Arun District Council
Arun Civic Centre
Maltravers Road
Littlehampton
West Sussex BN17 5LF
Planning & Building Control General Enquiries
Tel: (01903) 737756 Fax: (01903) 730442
Dx: 57406 Littlehampton
Minicom: 01903 732765
e-mail: planning@arun.gov.uk
website: www.arun.gov.uk/planning

Application No: R/102/20/PL
Site Address: Land North of Springfield House Cross Road Rustington BN16 2ST
Description of works: 1 No. detached 5-bedroom house with attached single storey double garage & carport.

Thank you for your internet representation made on 4th August 2020 which has been recorded as an objection with the comments as follows:

Proposed Entrance Elevation

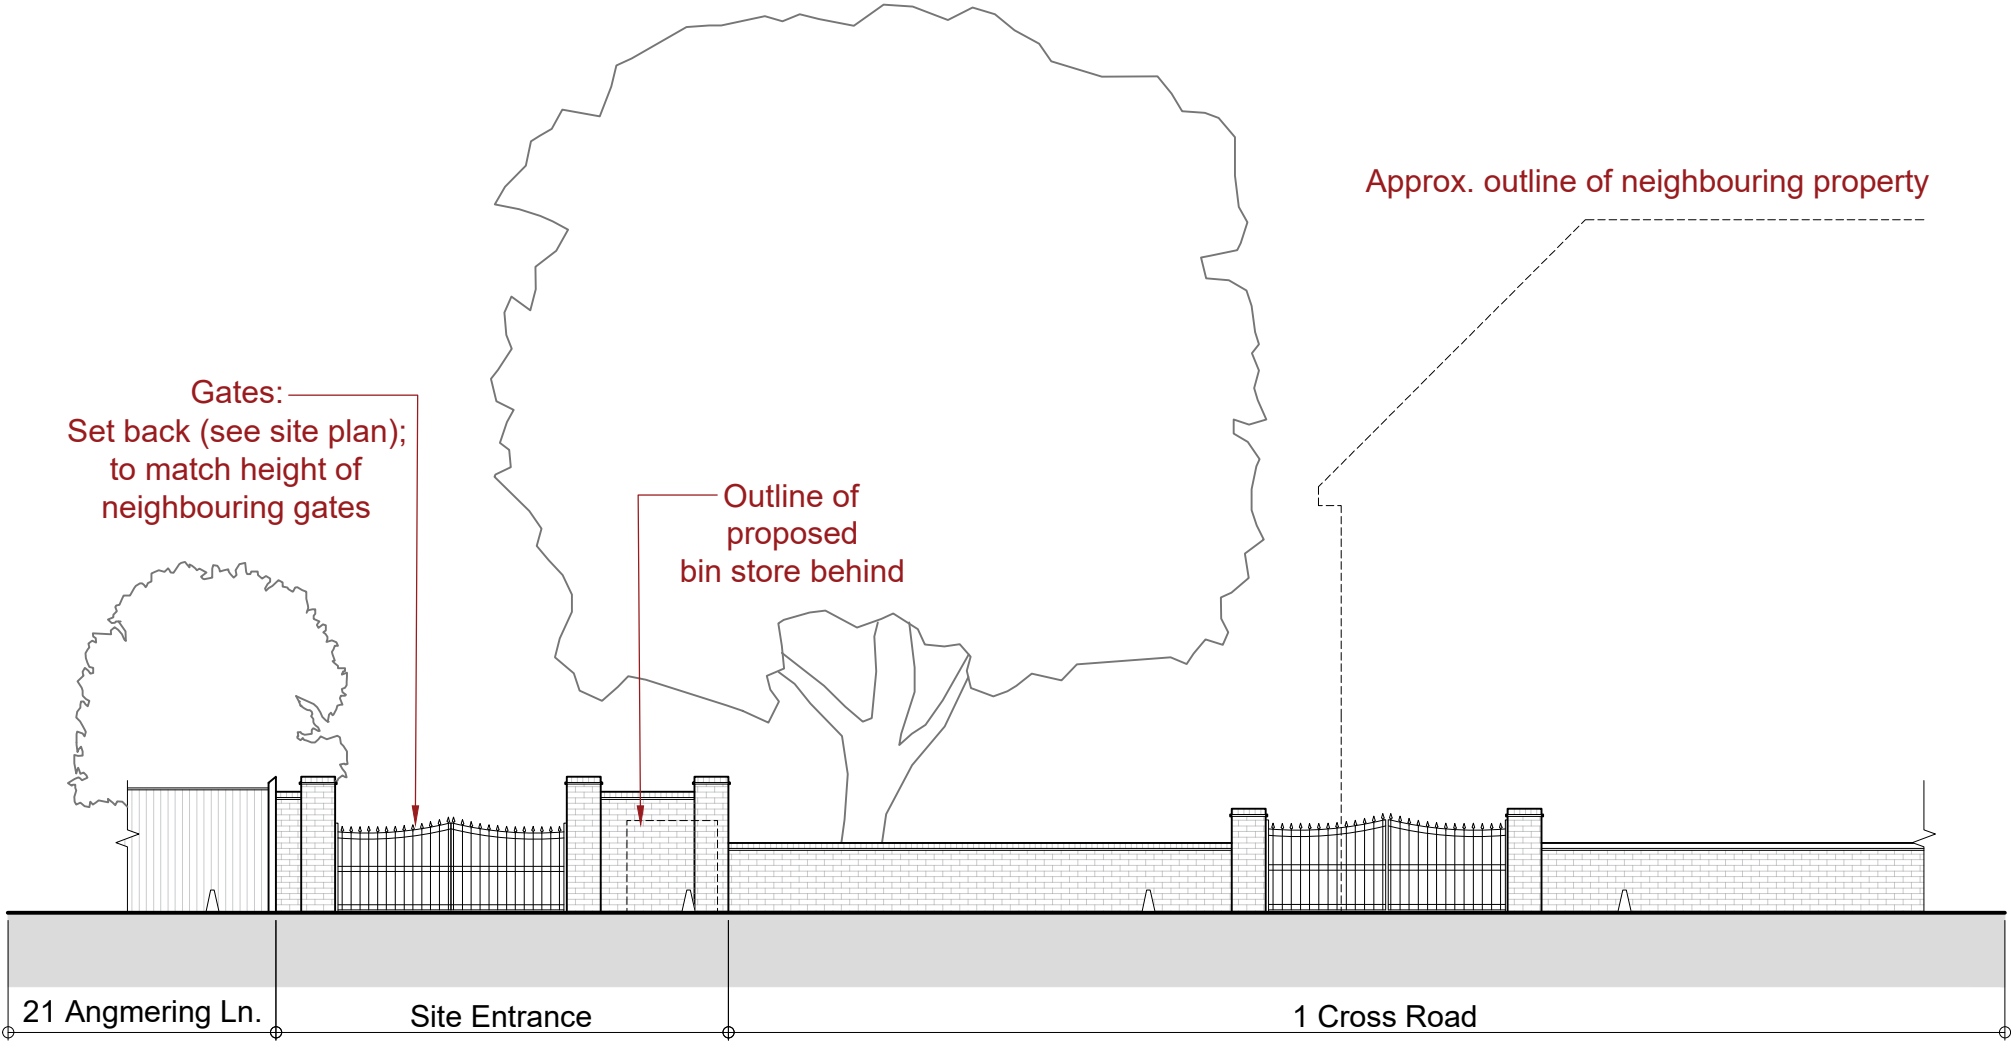
Given that we are directly adjacent, I have one key concern with the design, which is the gable that faces directly towards the rear of our property. This has a very large window at first floor to the en-suite and dressing room, which is wholly unnecessary and creates overlooking where there should be none. The house would not be affected if this window was reduced substantially and made a proper dormer rather than the imposing gable which is inappropriate on a side elevation.
